Boston Alternative Energy Facility

Secretary of State Additional Information Request

Natural England's updated advice on potential Air Quality impacts

11th November 2022

**Plate 1. Comparison of monitored emissions with the emission limit values from EfW plants in the UK**

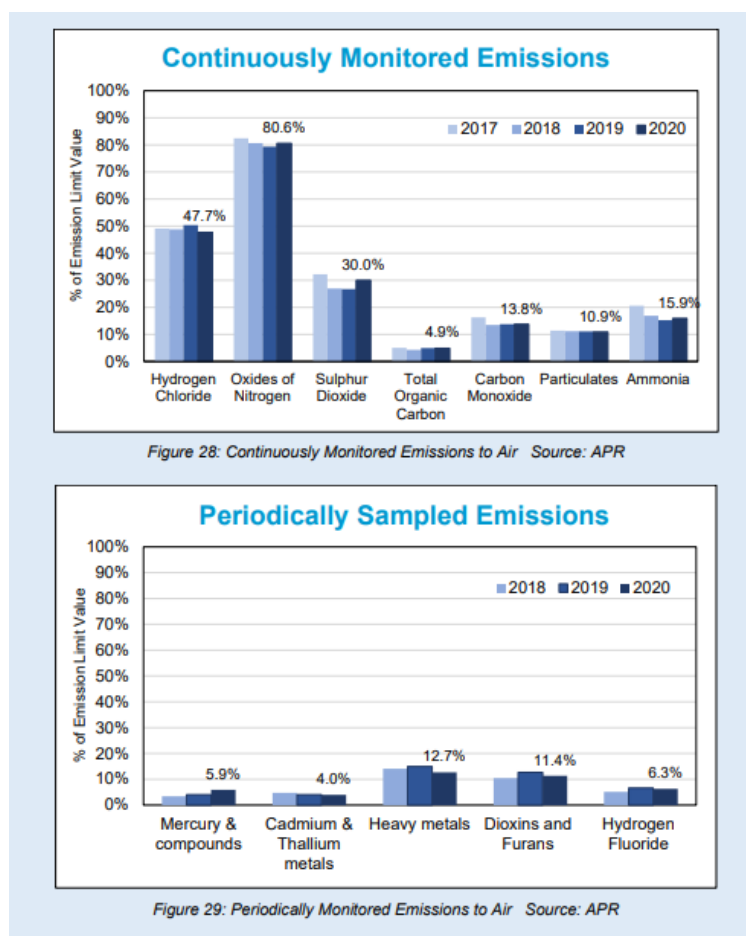
13. The Air Quality Deposition Monitoring Plan **[REP4-016]** indicates that a reduction of emissions from the “worst case basis” of 100% of the (Environmental Permit) permitted levels would be “likely”. This is based on emissions monitoring results of other EfW plants in the UK – showing typical emissions of NO_x are at approximately 80% of the permitted level and NH₃ are at around 20% of the permitted level. This is shown in **[REP6-035]**.

14. However, Natural England advises that there is no commitment by the Applicant to cap emissions at these levels, and it must therefore be assumed the assessed “emission limits” are a reasonable worst case in the assessment. **This is not therefore considered mitigation for the purpose of reducing potential impacts at the designated sites.**
